APPENDIX 5 : INDEPENDENT SEPP 65 REVIEW

**Proposed Mixed Use Redevelopment
6-16 Atchison Street, St Leonards
GENERAL DESIGN COMPLIANCE REVIEW**

Documents reviewed:

North-South Section

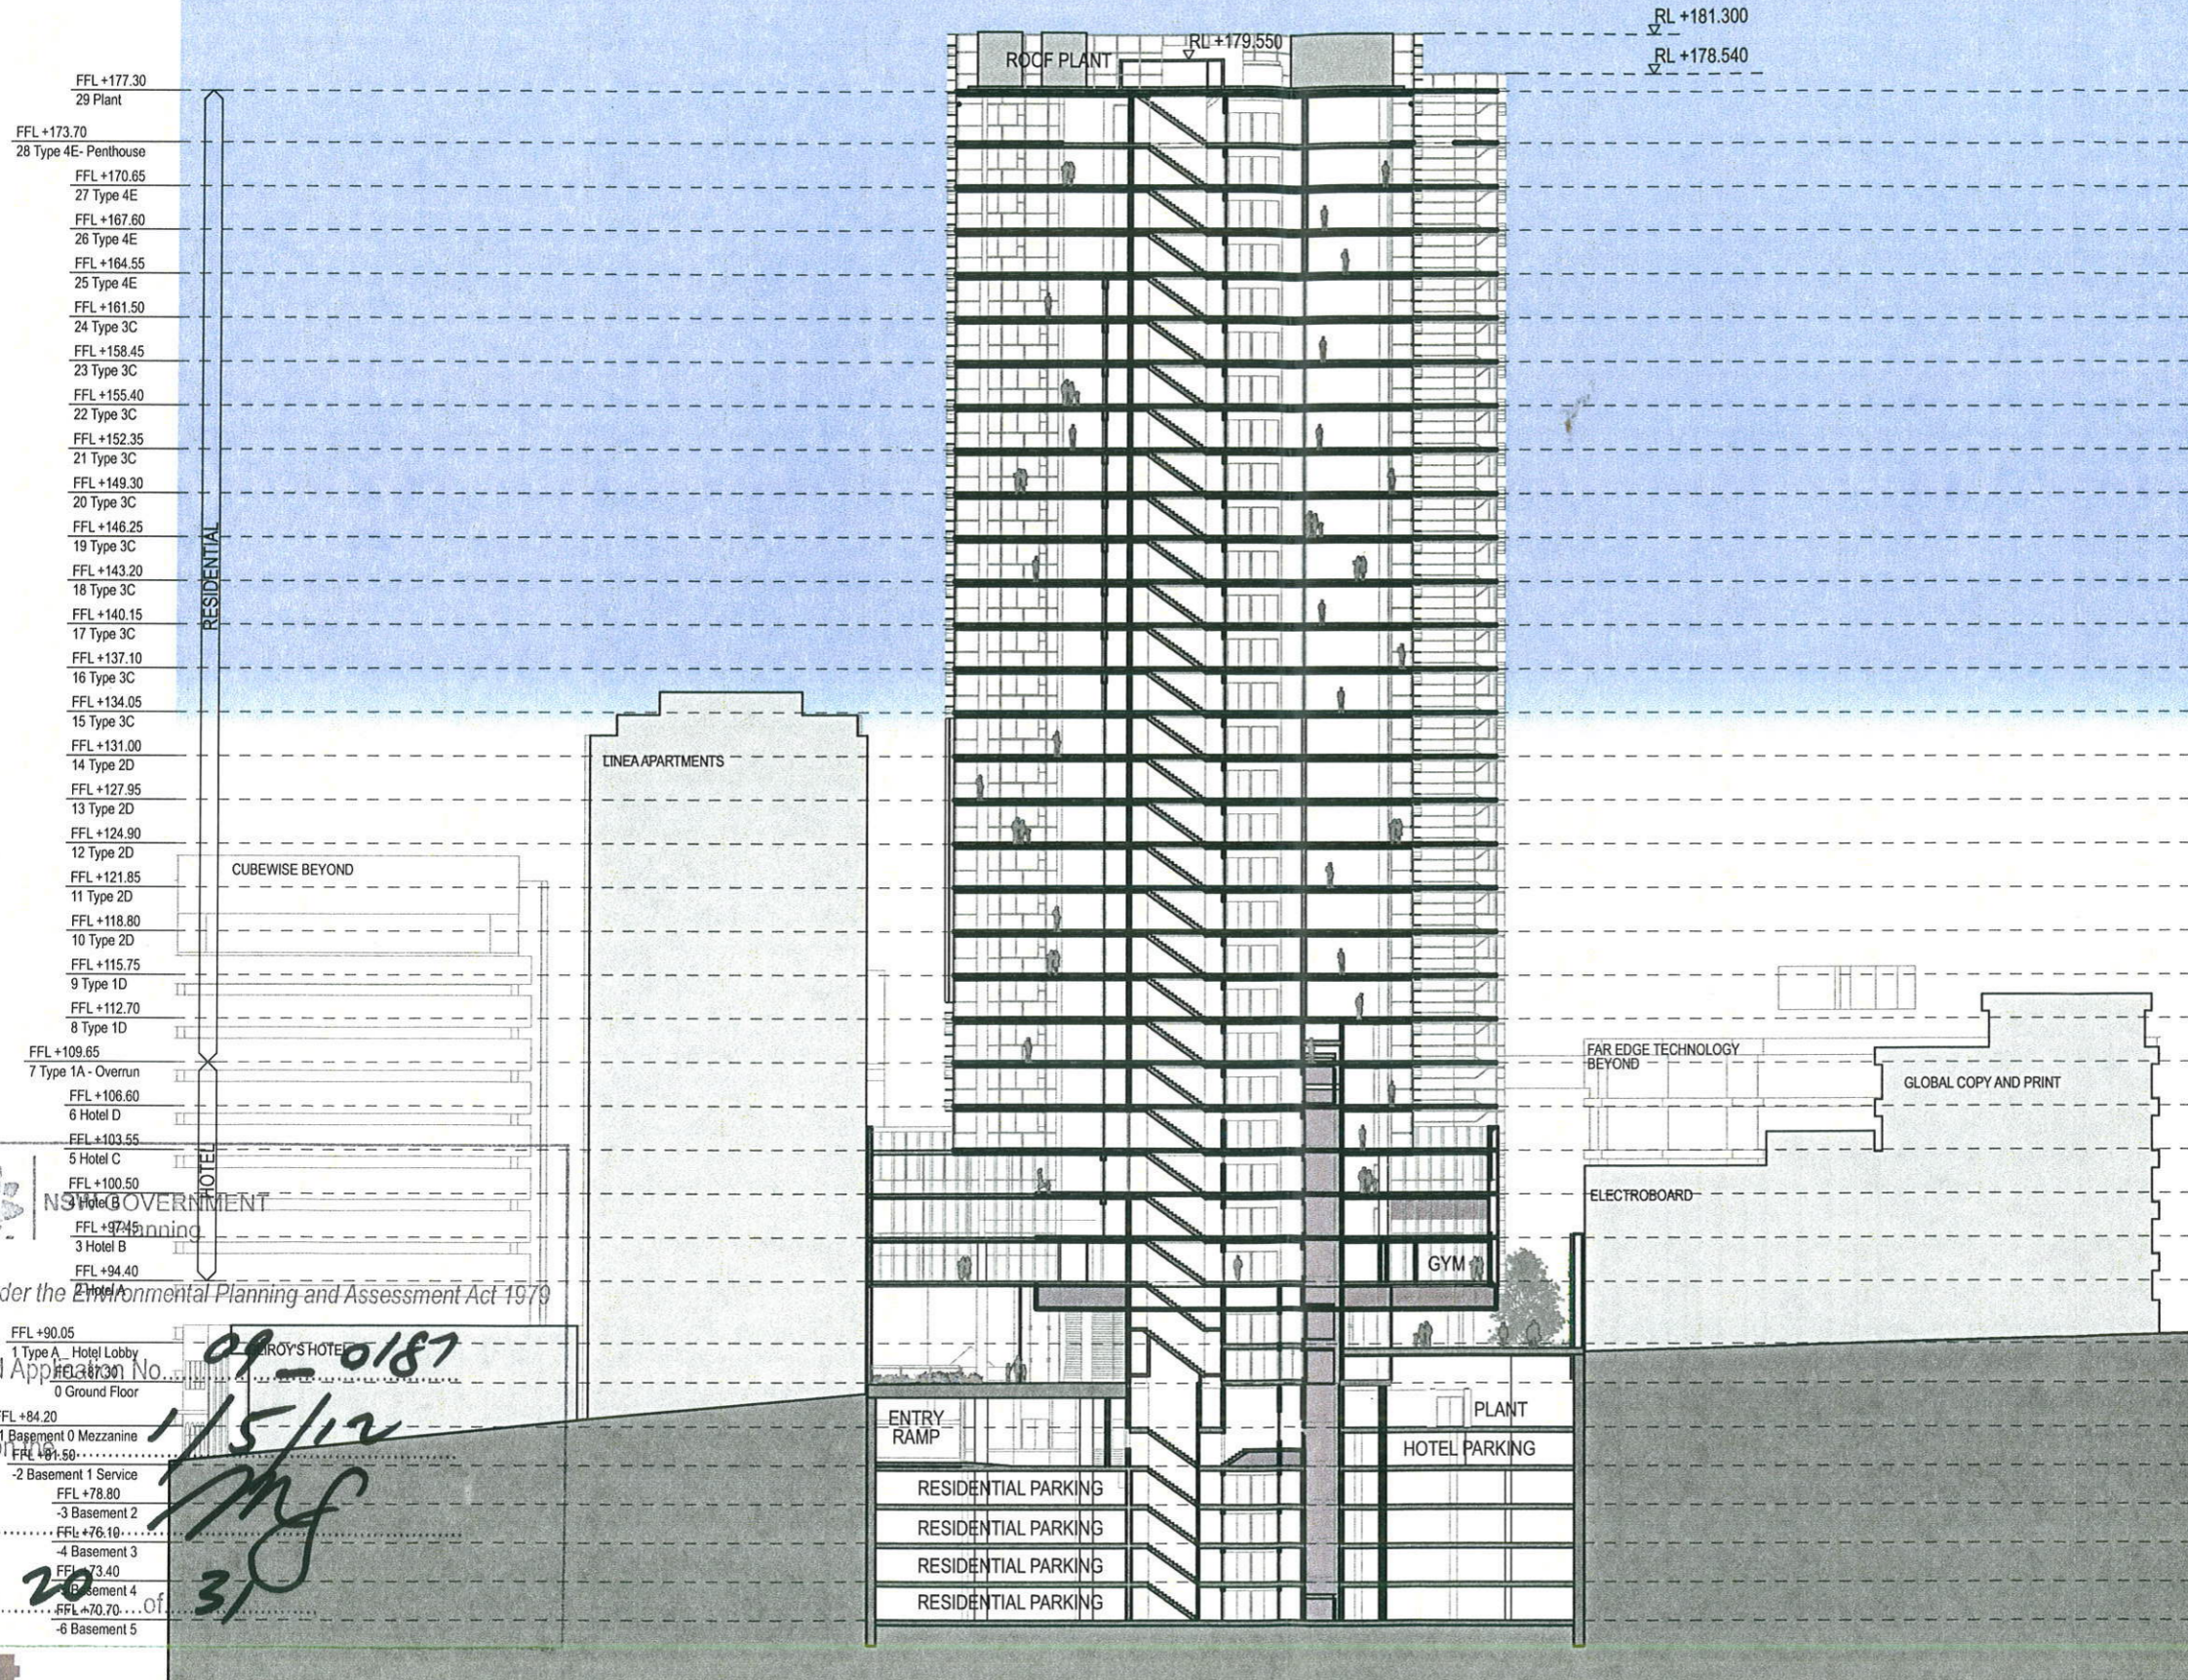
The distance between the existing eight storey building and the proposal is around 16.5 metres. This is greater than the 13 metres required between habitable and non-habitable rooms and is therefore considered adequate.

If this building's use was changed to residential in the future then it would be required to be further setback to achieve an 18 metre separation. As the existing commercial building is very deep, narrowing the building if it is converted to residential is considered desirable and therefore the proposed setback is considered reasonable. If additional residential use was placed above the existing height of this building in the future, then it would be required to be further setback to achieve a 24 metre separation. Again, as the existing commercial building is very deep, narrowing the building is considered desirable and therefore the proposed setback is considered reasonable.

03 PLAN Typical Serviced Apartments L2-7
1:500

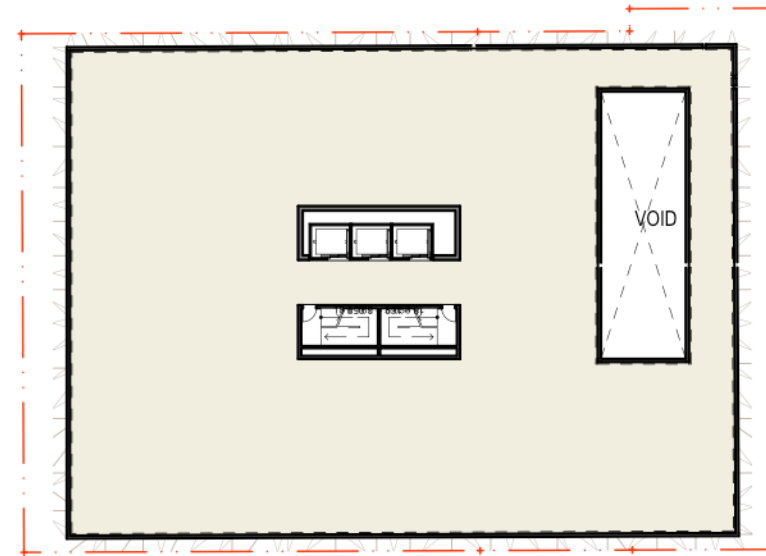
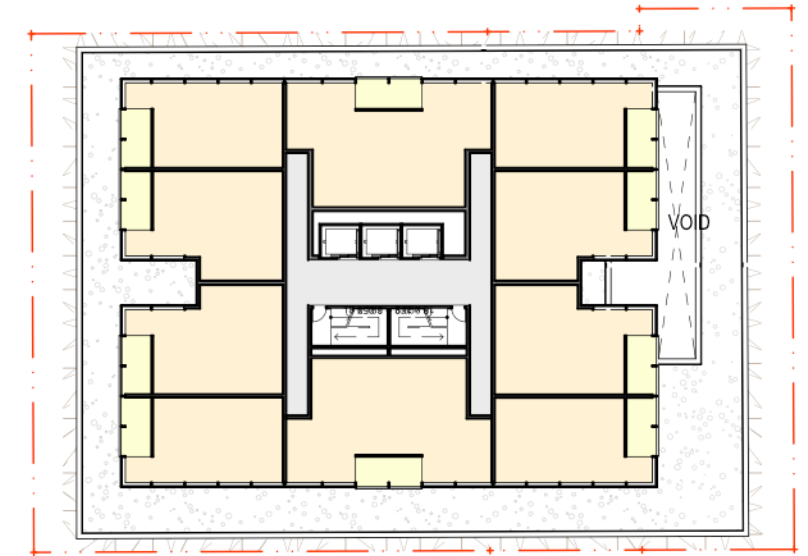
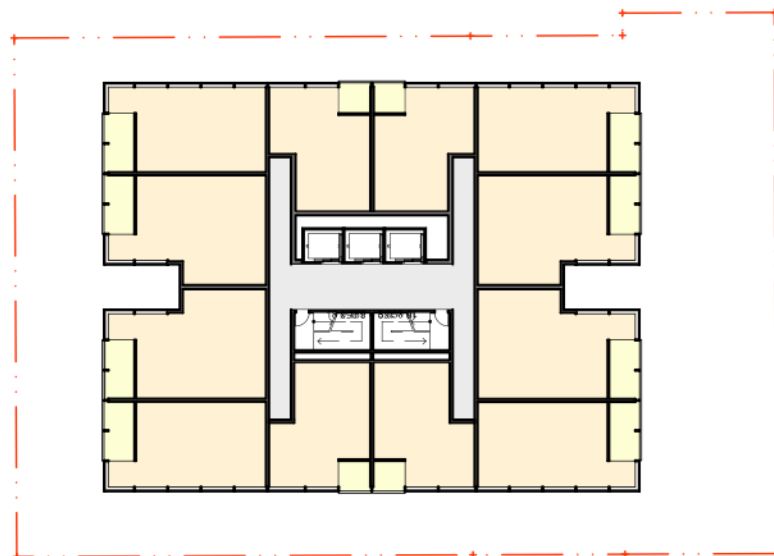
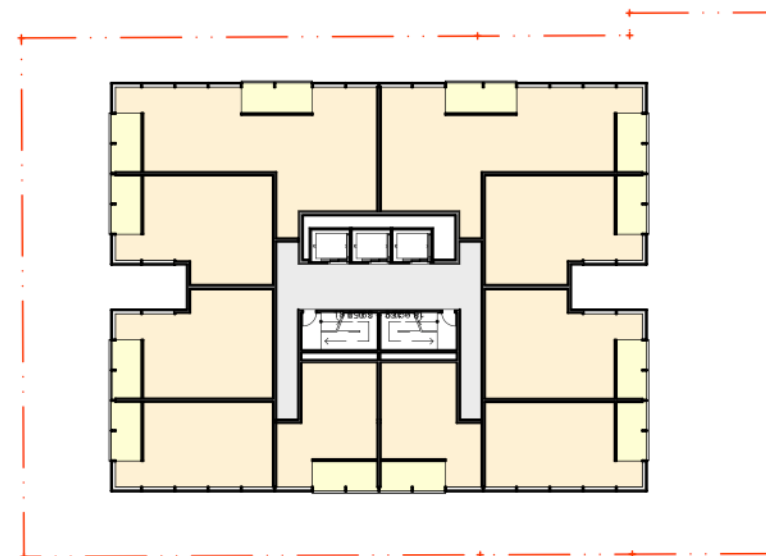
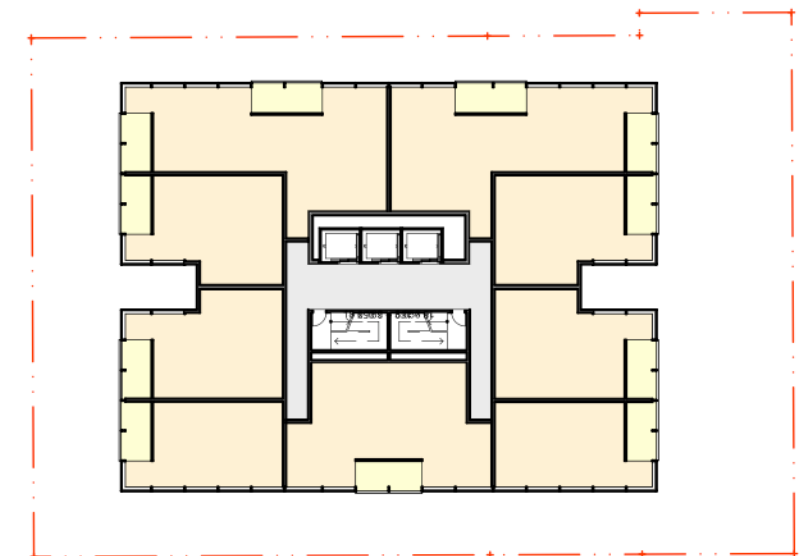
On Type 1A Plan: 6 residential units being all those on the external corners of the plan are naturally cross ventilated.

On Type 1D Plan: 6 residential units being all those on the external corners of the plan are naturally cross ventilated.

On Type 2D Plan 6 residential units being all those on the external corners of the plan are naturally cross ventilated.

On Type 1A Plan: 9 residential units receive a minimum of two hours direct sunlight between 9 am and 3 pm in mid winter being all those on the north and west part of the plan.

On Type 1D Plan: 8 residential units receive a minimum of two hours direct sunlight between 9 am and 3 pm in mid winter being all those on the north and west part of the plan.

On Type 2D Plan: 8 residential units receive a minimum of two hours direct sunlight between 9 am and 3 pm in mid winter being all those on the north and west part of the plan.

01 PLAN Typical Mid Tower L22-24 T3
1:500

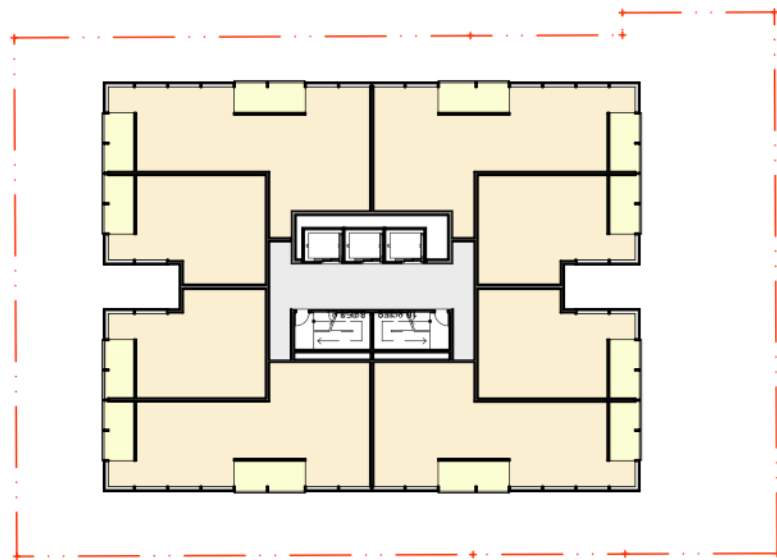
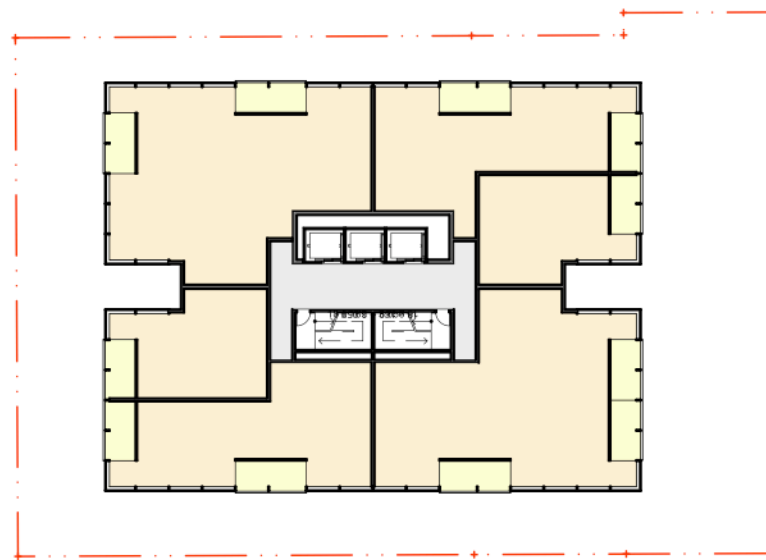
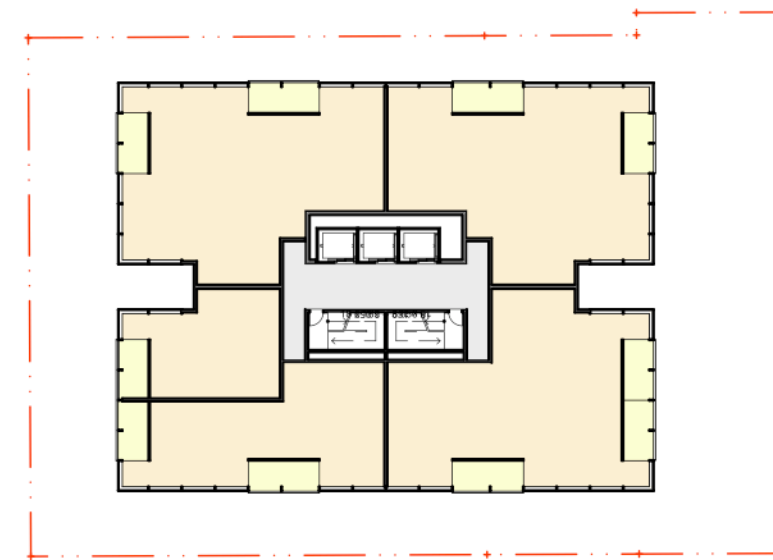
On Type 3C Plan 4 residential units being all those on the external corners of the plan are naturally cross ventilated.

On Type 3C Plan: 5 residential units receive a minimum of two hours direct sunlight between 9 am and 3 pm in mid winter being all those on the north and west part of the plan.

03 PLAN Typical High Tower L28-29 T2
1:500

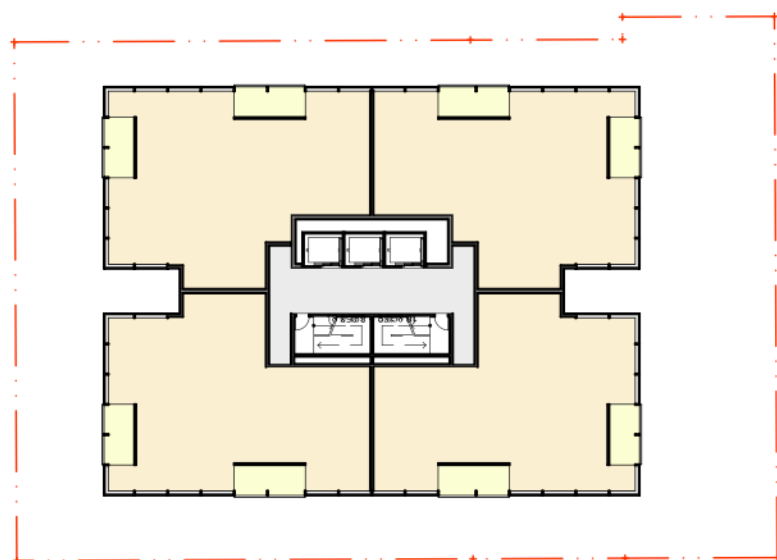
On Type 4E Plan 4 residential units being all those on the external corners of the plan are naturally cross ventilated.

On Type 4E Plan: 4 residential units receive a minimum of two hours direct sunlight between 9 am and 3 pm in mid winter being all those on the north and west part of the plan.
